Our Ref: BE/134/19/HH
Your Ref:

Town & Country Planning Act 1990 (as amended)
Town & Country Planning (Development Management Procedure) (England) Order 2015
Application for Planning Permission for Works or Extension to a Dwelling

Development proposed side extension
Location 19 Ashurst Close Bersted

Proposed North Elevation

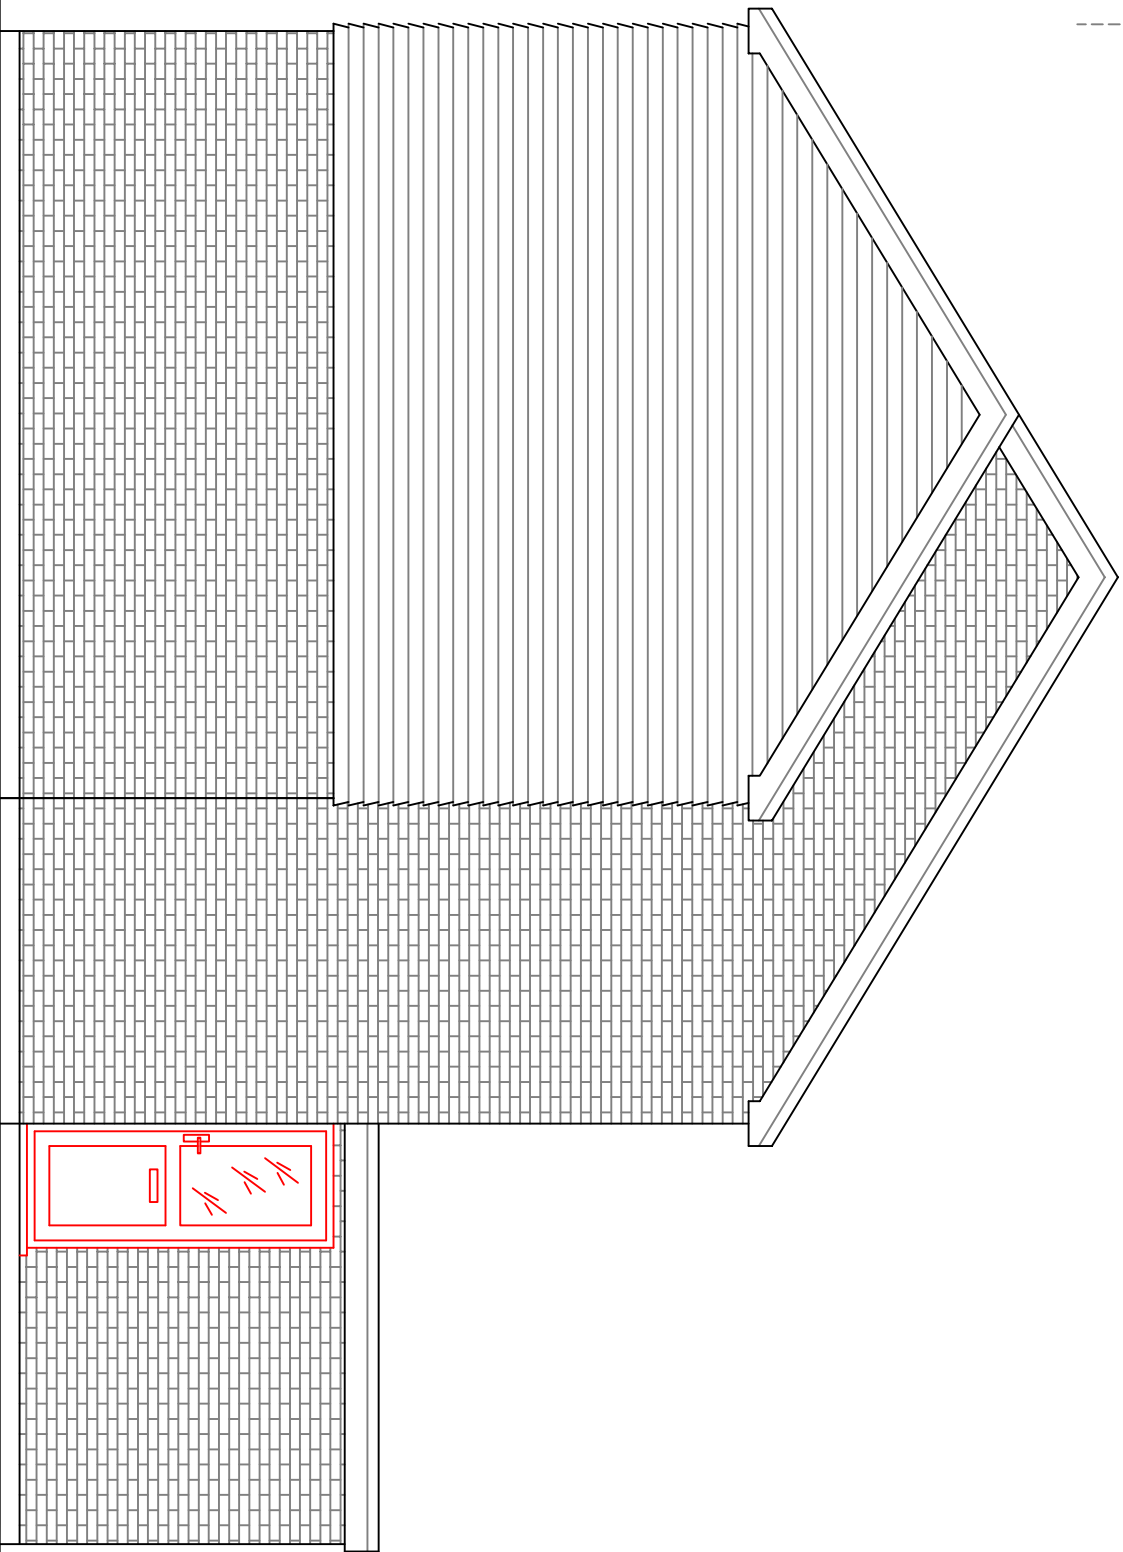
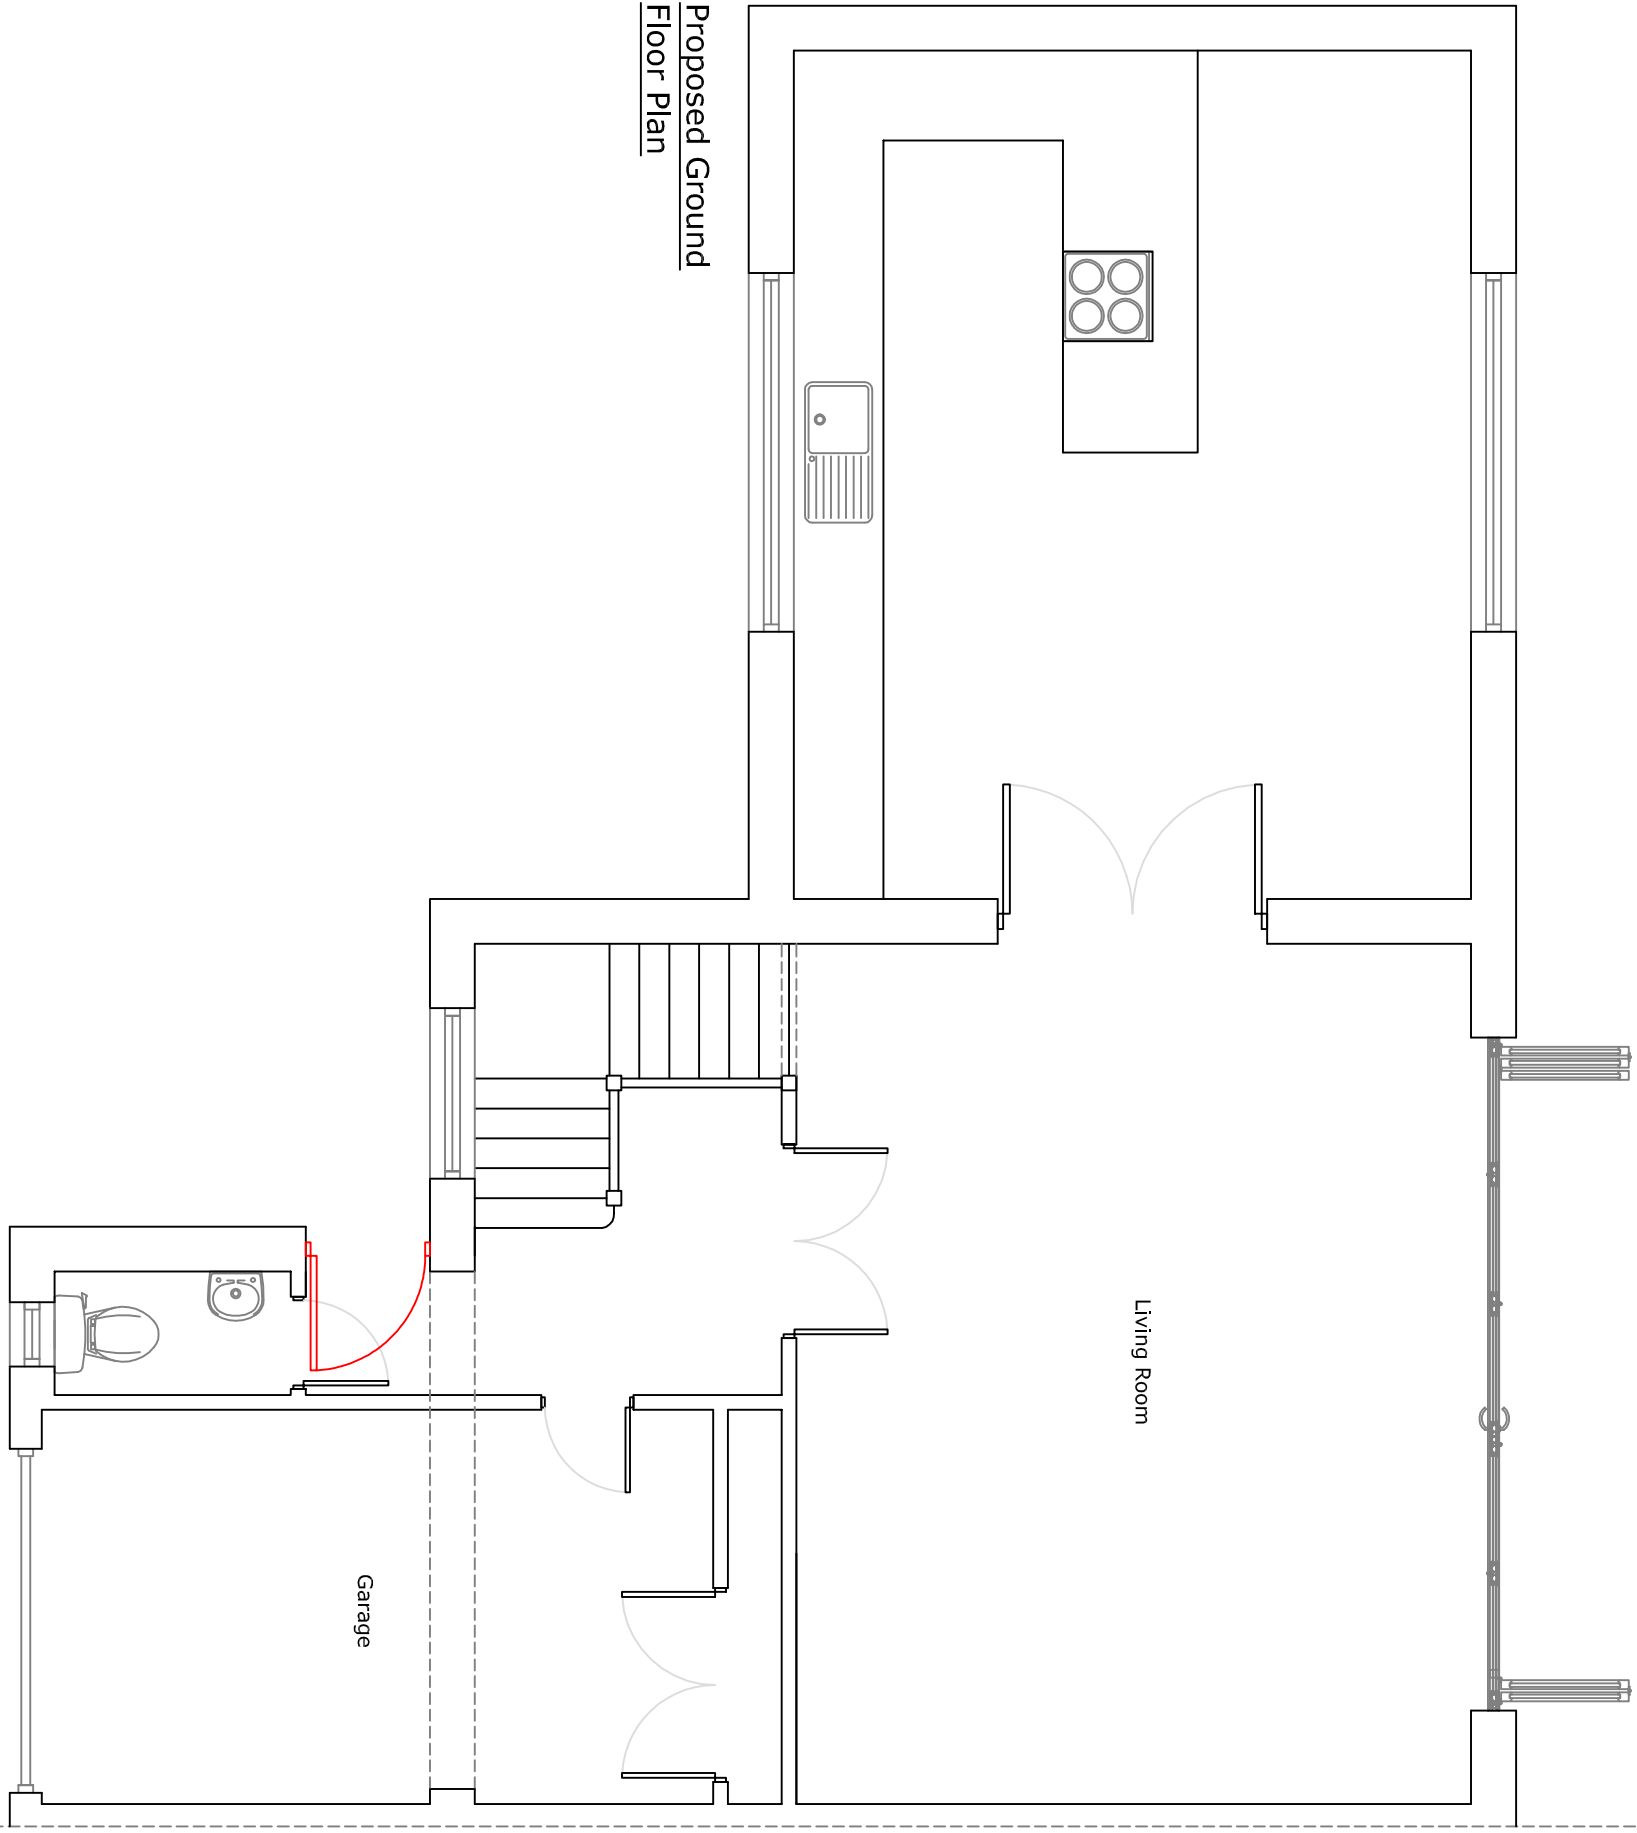
The proposed north elevation is inconsistent with the proposed ground floor. Please amend.
